Town & Country Planning Act 1990 (as amended)
Town and Country Planning (Development Management
Procedure) (England) Order 2015
Application for Planning Permission
DECISION NOTICE

Application Ref: LU/71/15/PL

10 St Catherines Road
 Littlehampton
 BN17 5HS

Conversion of Ground & First floor at the rear into two 2 bedroom flats.

NEW GROUND FLOOR PLAN AND FLAT 1

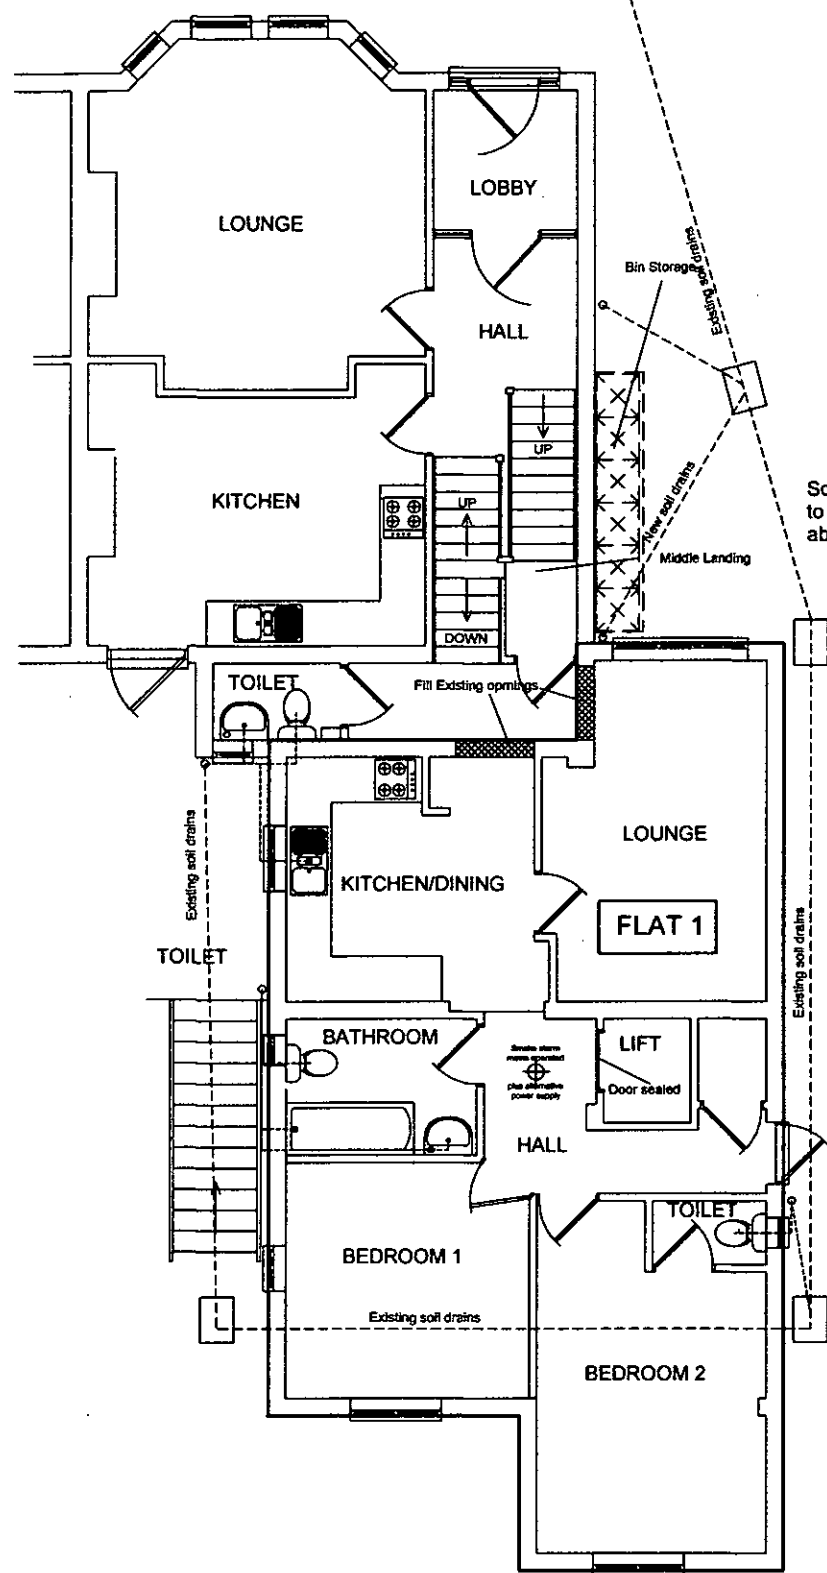
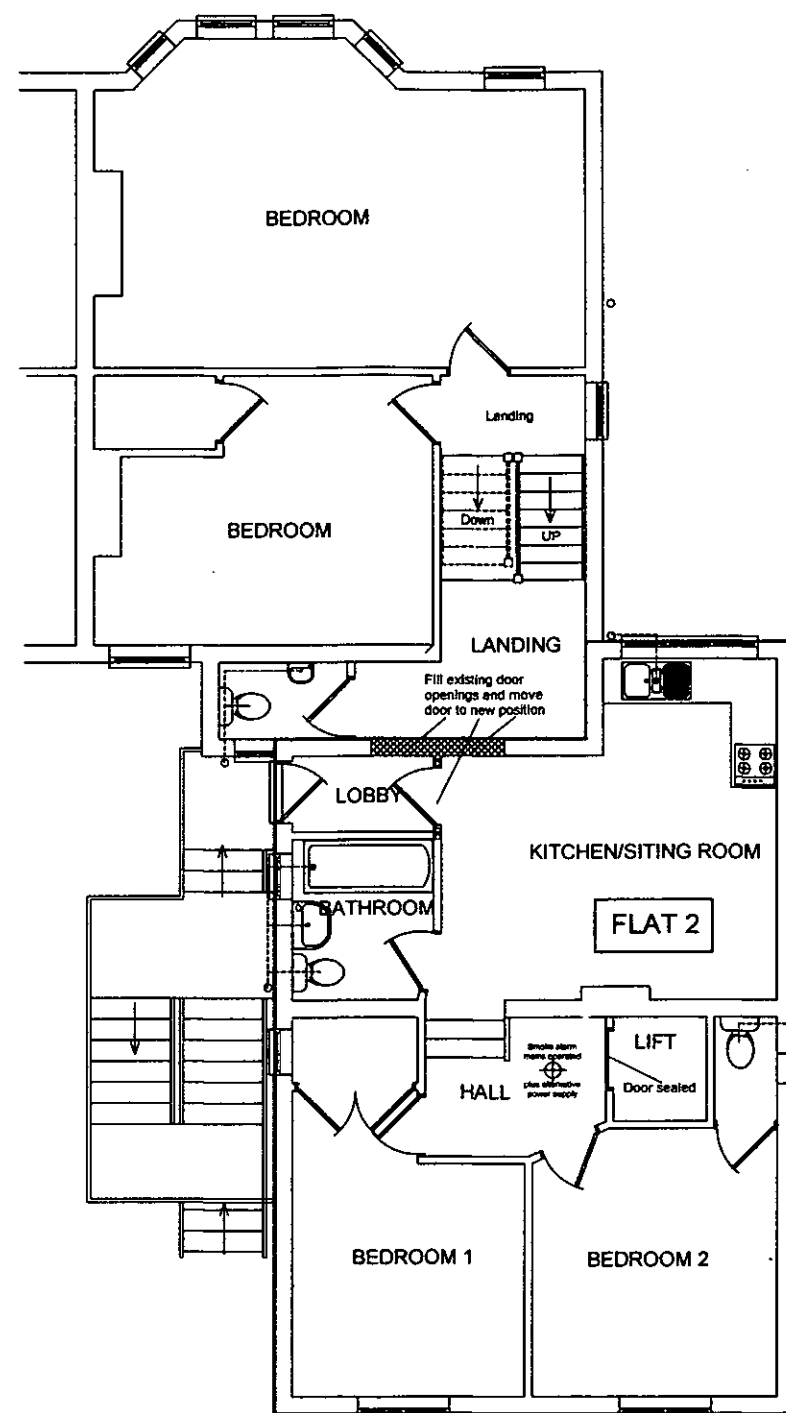
- 1 Having regard to the size of the rooms the conversion of the premises into 2 separate 2 bedroom units of accommodation would give rise to an unsatisfactory residential environment for future occupiers in conflict with policy GEN7 of the Arun District Local plan and policy DDM2 of the Publication Version of the Emerging Arun District Local Plan (October 2014) and the National Planning Policy Framework.
